COMMUNITY SERVICES DEPARTMENT

February 2, 2022

Subject: Monument Academy Minor Subdivision (MS-2110)

MA SUBDIVISION

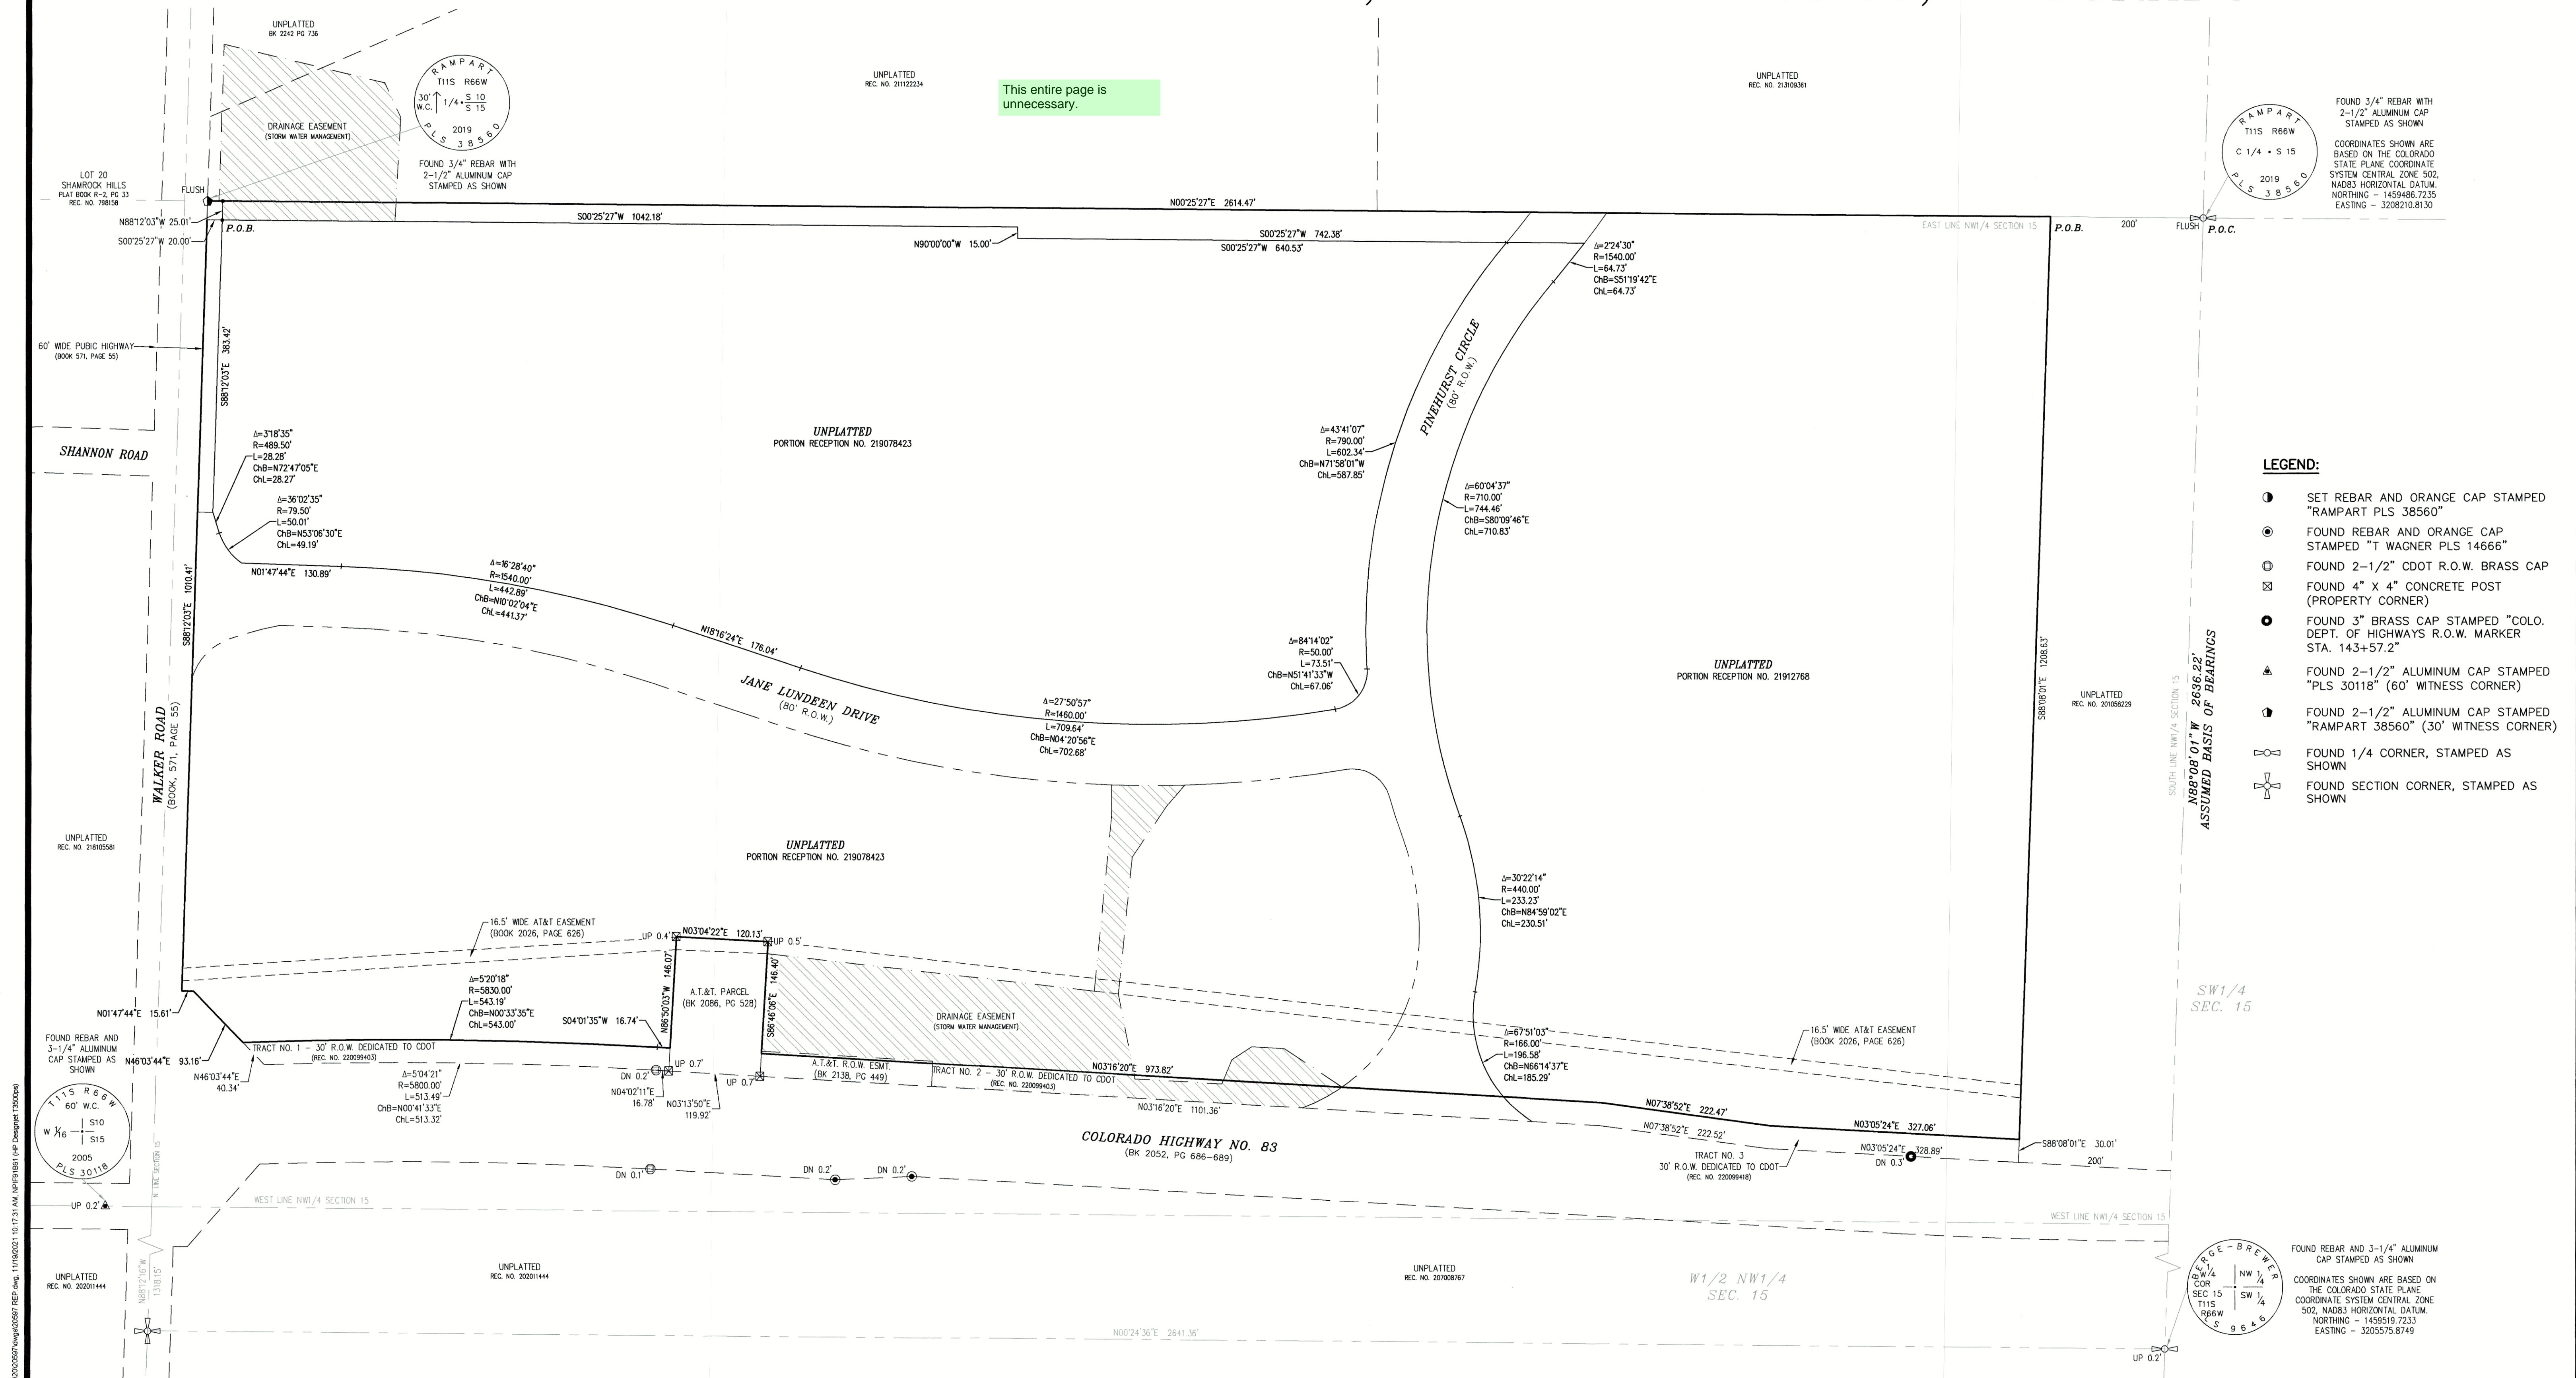
constructed and is already being used. This trail is also proposed to facilitate a non-motorized connection to the school site within the Monument Academy development at the southern end of the property. Staff has reviewed the final plat drawings and notes that sidewalks are planned, with several already constructed, to facilitate a connection from the Monument Academy development to the Cherry Creek Trail. Staff would appreciate that at the culmination of this project the sidewalks along Pinehurst Circle are constructed and connected to the Cherry Creek Trail.

No regional park fees are required for the application, as the Board of County Commissioners has elected to not require park fees for commercial subdivisions. However, required park fees may be assessed in the future for Tracts A and B at time of platting depending on land use. Staff would also like to see the sidewalks along Pinehurst Circle be constructed to the Cherry Creek Trail. These comments are being provided administratively, as this application does not require Park Advisory Board consideration. Please let me know if you have any questions or concerns.
